From: David Lowin
Sent: 02 September 2021 11:56
To: Tim Screen
Cc: DC Support; John Jowitt
Subject: RE: 21/01454/F - Former Rodney House Private Drive Off, Graven Hill Road, Ambrosden

From: Tim Screen <Tim.Screen@Cherwell-DC.gov.uk>
Sent: 02 September 2021 10:42
To: David Lowin <David.Lowin@Cherwell-DC.gov.uk>
Subject: RE: 21/01454/F - Former Rodney House Private Drive Off, Graven Hill Road, Ambrosden

I would advise that that native trees are planted within the native shrub planting on the boundaries – in actual fact a rather narrow native hedge on the eastern and southern boundaries (I recommend Acer campestre trees 12-14 cm). Native trees associate more effectively with native planting than ornamental trees.....and not so regimented in their spacings: 5 – 7 metres apart is more natural. There is insufficient depth in the planting to allow for a mown grass verge between the parked vehicle and the hedge. This is to allow for people to access the rear of their vehicles without too much impingement from hedgerow outgrowth. The northern native thicket will also require native trees to visually mitigate the development for the benefit of residential receptors, however the adjoining d

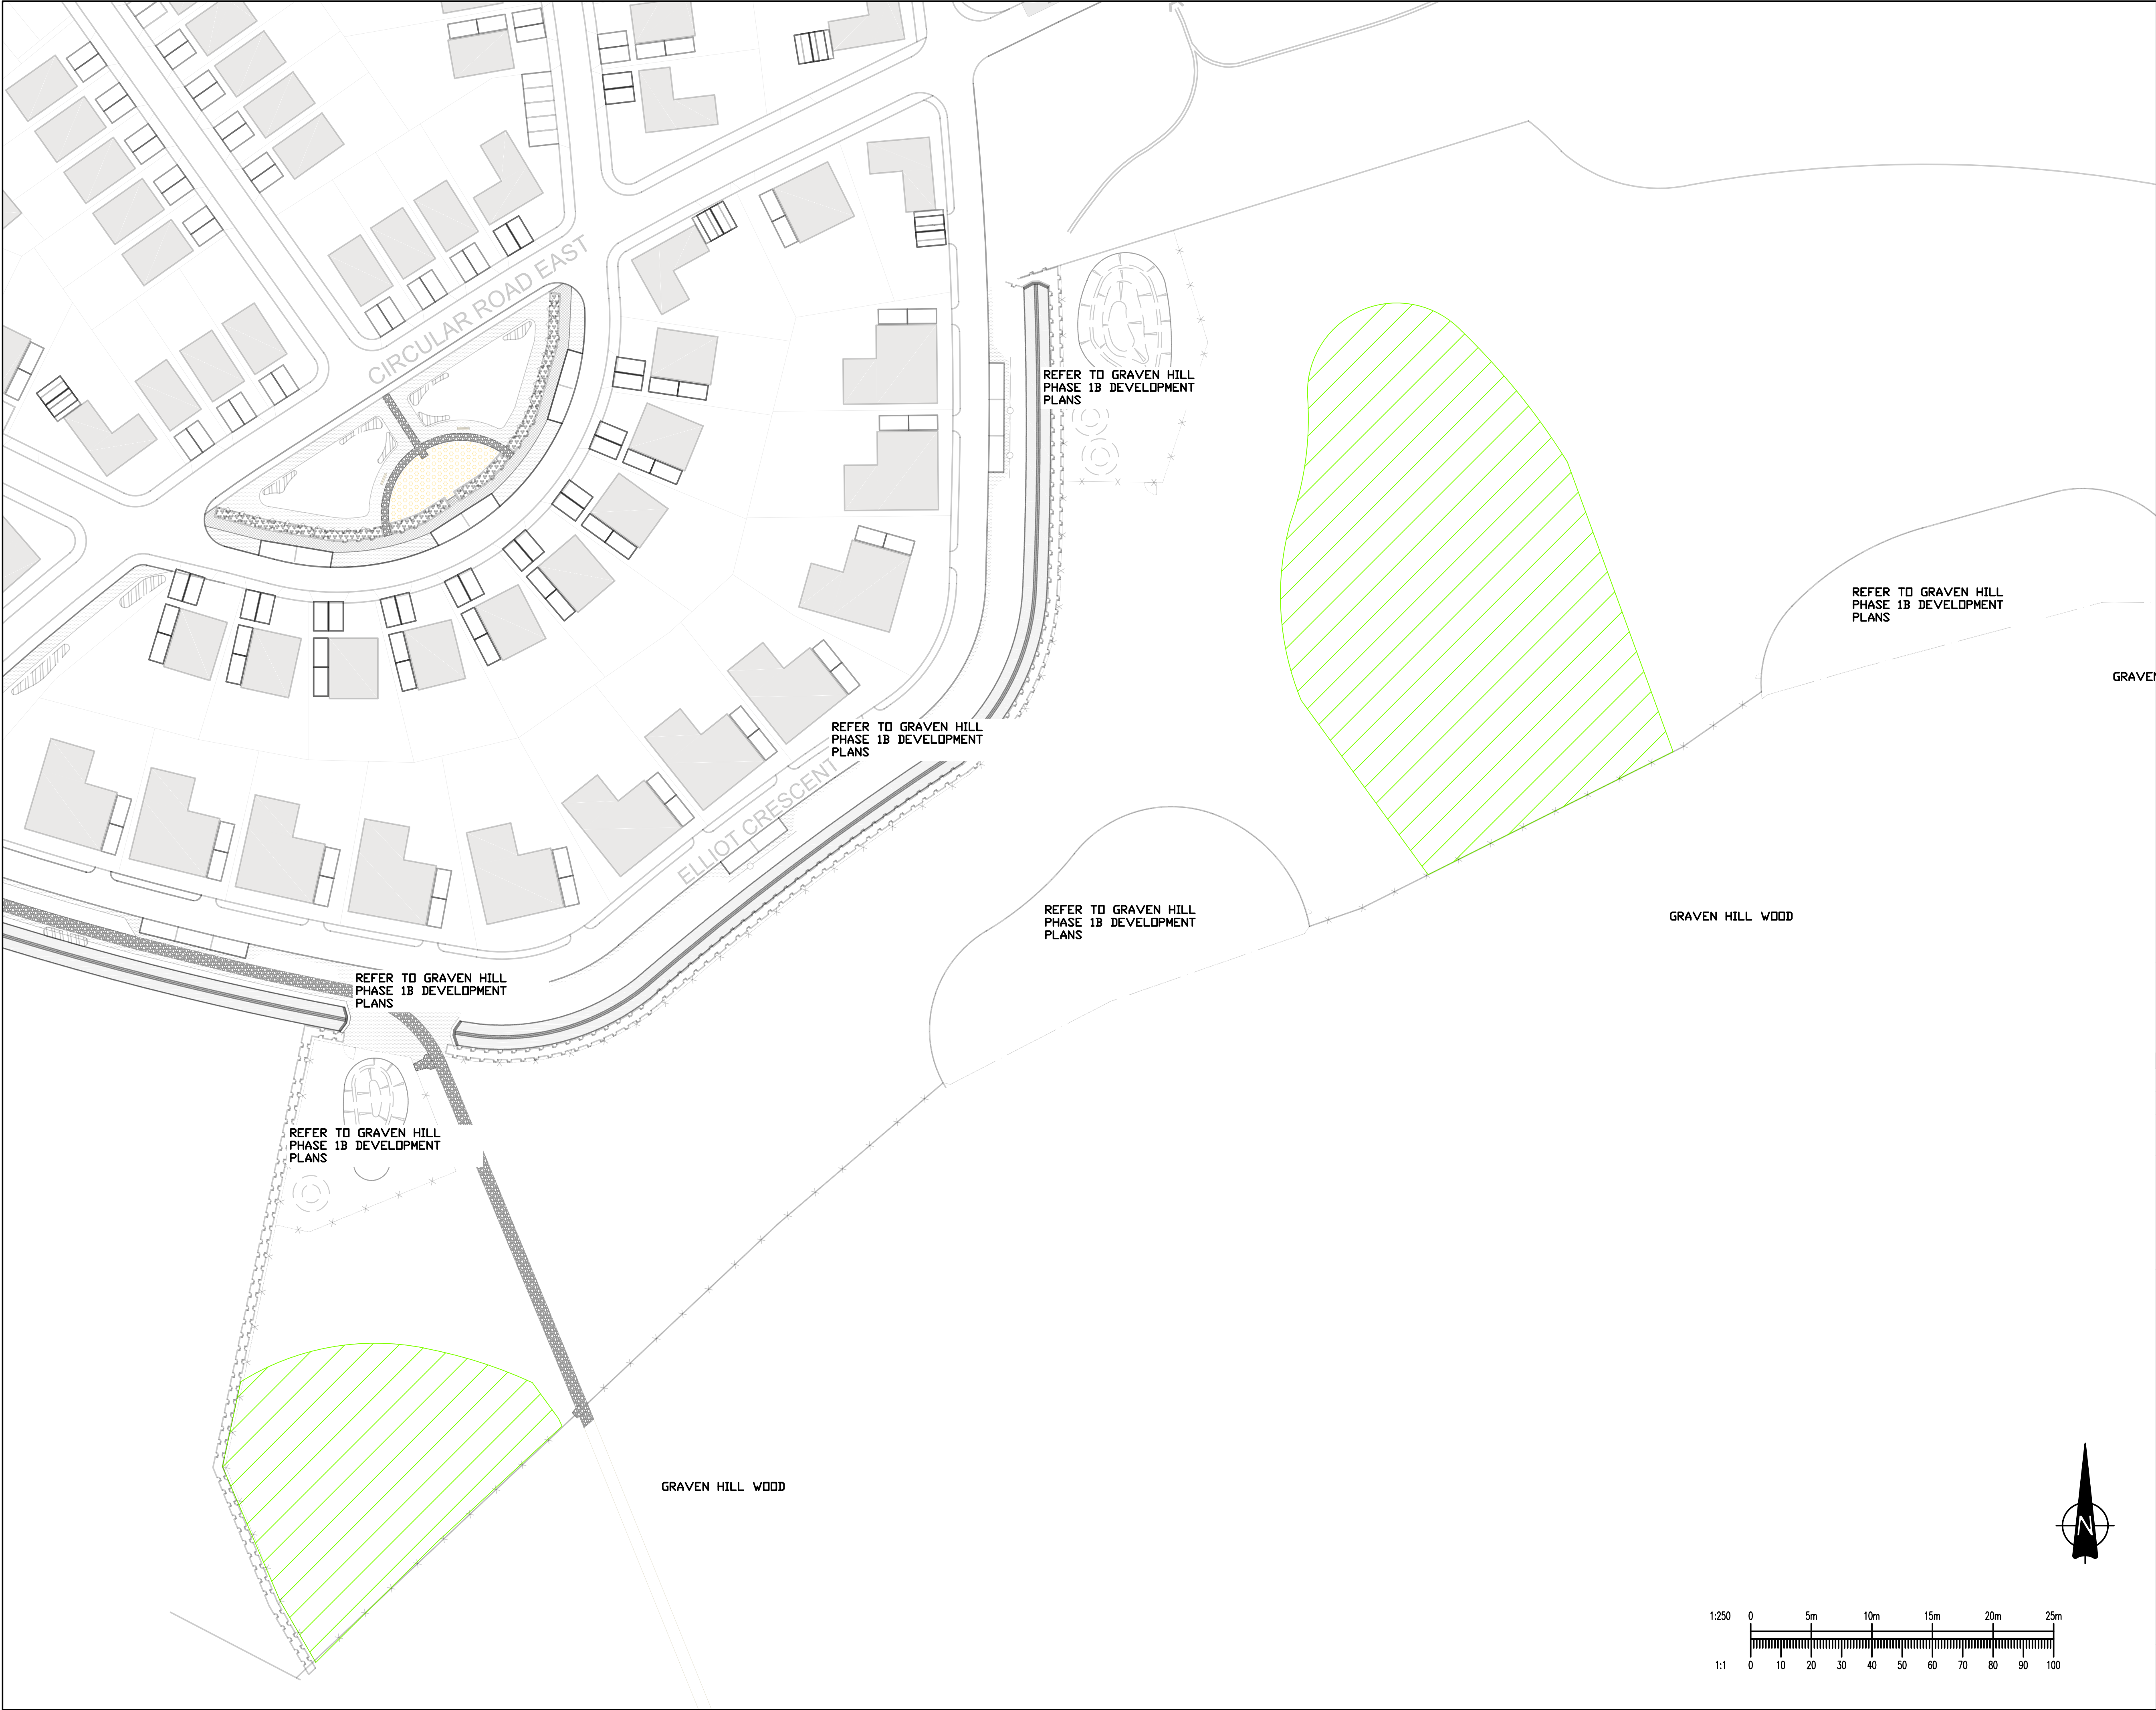
Tree root deflectors should be indicated on the landscape drawings.

The ornamental hedgerow between the car park and the sculpture area should be allowed to establish with post and wire fence protection. All too often people take shortcuts through structural landscaping

and trampling it. This will also occur to ornamental shrubberies on the car park, hence the need for knee rail fencing along the length of the shrubberies.

I would suggest the central courtyard is used for small children's play with seating area. The planting will have to be non-toxic, non-thorny/spiny where young children are involved. The courtyard will be very shady for most of the day. There will also be a rain shadow cast by the building. The plant species selected should be able to cope with these conditions. An irrigation system should be considered.

How is the landscaping to be managed and maintained and which party will be doing this? This is crucial to the establishment and quality of the landscaping.
